From: planning.responses@arun.gov.uk [<mailto:planning.responses@arun.gov.uk>]
Sent: 31 July 2017 11:03
To: SU Local Development
Subject: Planning Consultation on: FG/115/17/PL

APPLICATION NO: FG/115/17/PL

Site Address: 44 Ferringham Lane Ferring BN12 5LU

Description of Works: 4 No. bungalows

DWG No. 628-02 rev. A

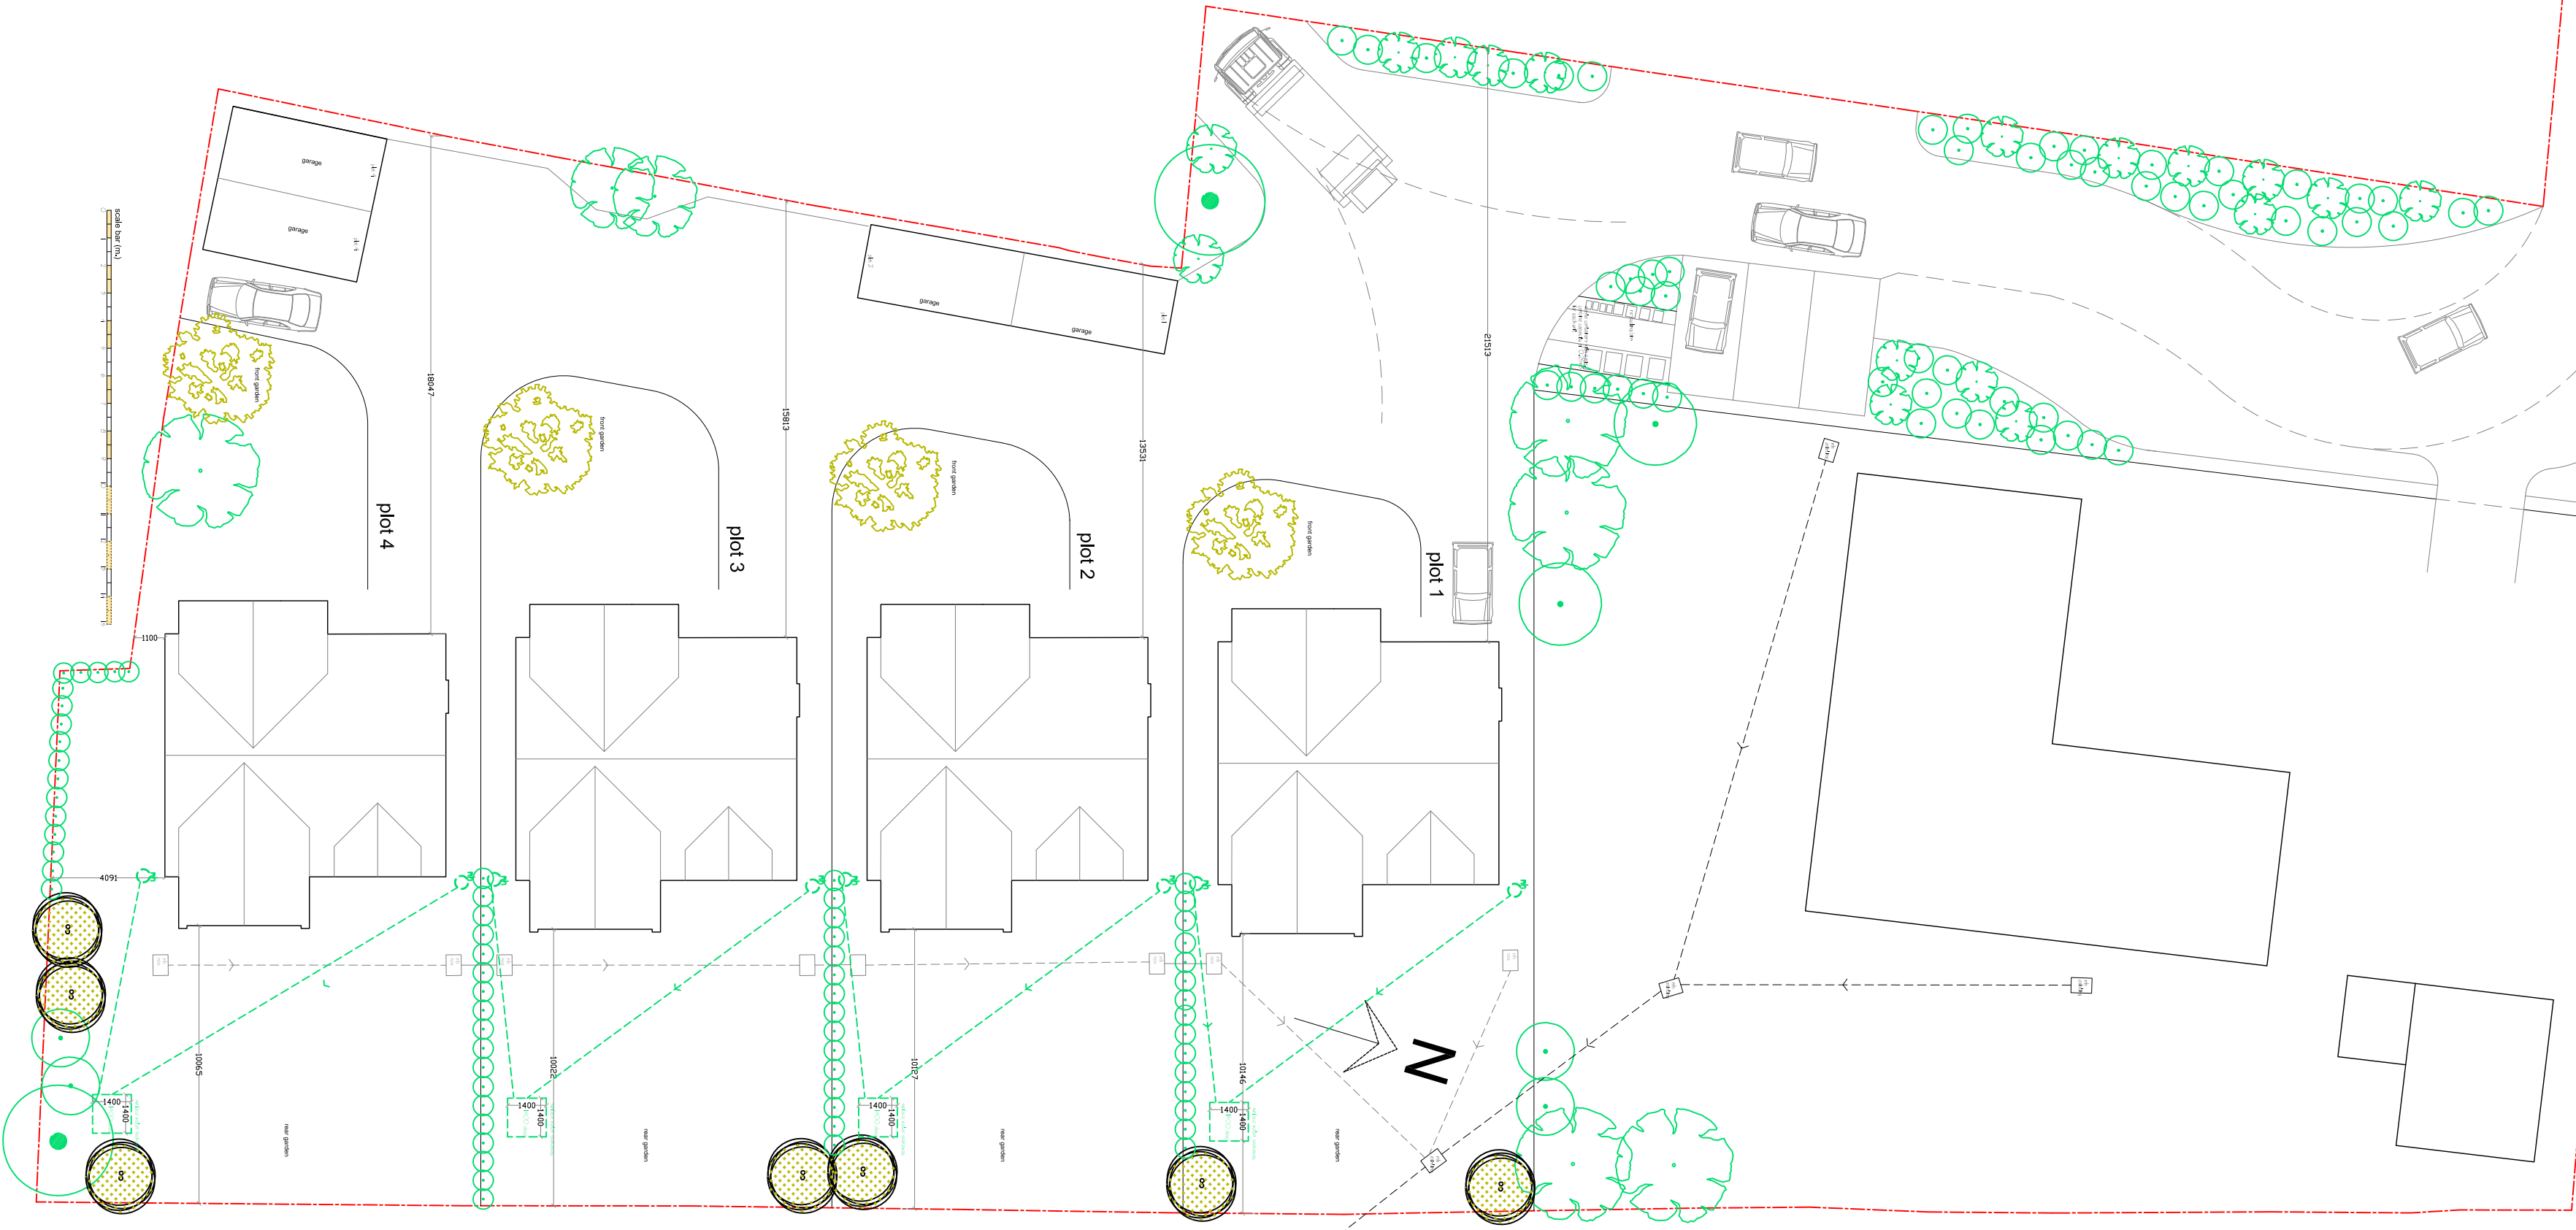
From inspection of the proposed site plan (628-02 Rev A) each dwelling will be provided with a hardstanding parking provision and a garage parking provision. An additional three car parking spaces will be provided, presumably to provide unallocated additional/visitor parking. I can confirm such a quantity of parking would be considered appropriate to meet the needs of the development.

However I note the proposed garages scale to 5.5 x 2.5 metres in size. WSCC advise that garages measure a minimum of 3 x 6 metres as per the West Sussex County Council Guidance for Parking in New Residential Developments September 2010 document. It would be advised that the garages are increased in size to meet this advice; I would accept that such matters could be dealt with via planning condition. Should the garages be increase to this size they would also be considered large enough to facilitate the parking of cycles as per current sustainable travel policies.

Full swept path tracking for fire and refuse vehicles has not been provided within the current application documents. I would be minded to accept that the layout proposed does have an open area larger than that demonstrated for turning of large vehicles under FG/69/16/OUT and would therefore be considered acceptable.

The Local Highways Authority would not be minded to raise any overriding concerns with the proposed development, however would advise that the proposed garages are increased in size as described above.

If the LPA are minded to grant planning consent it would be advised that conditions 5, 6, 7, 8, as per the Planning Inspectorate Appeal Decision APP/C3810/W/17/3166634 are once again applied. Please note the wording of Condition 8 would require the advised revision to garage sizes to be demonstrated prior to determination.
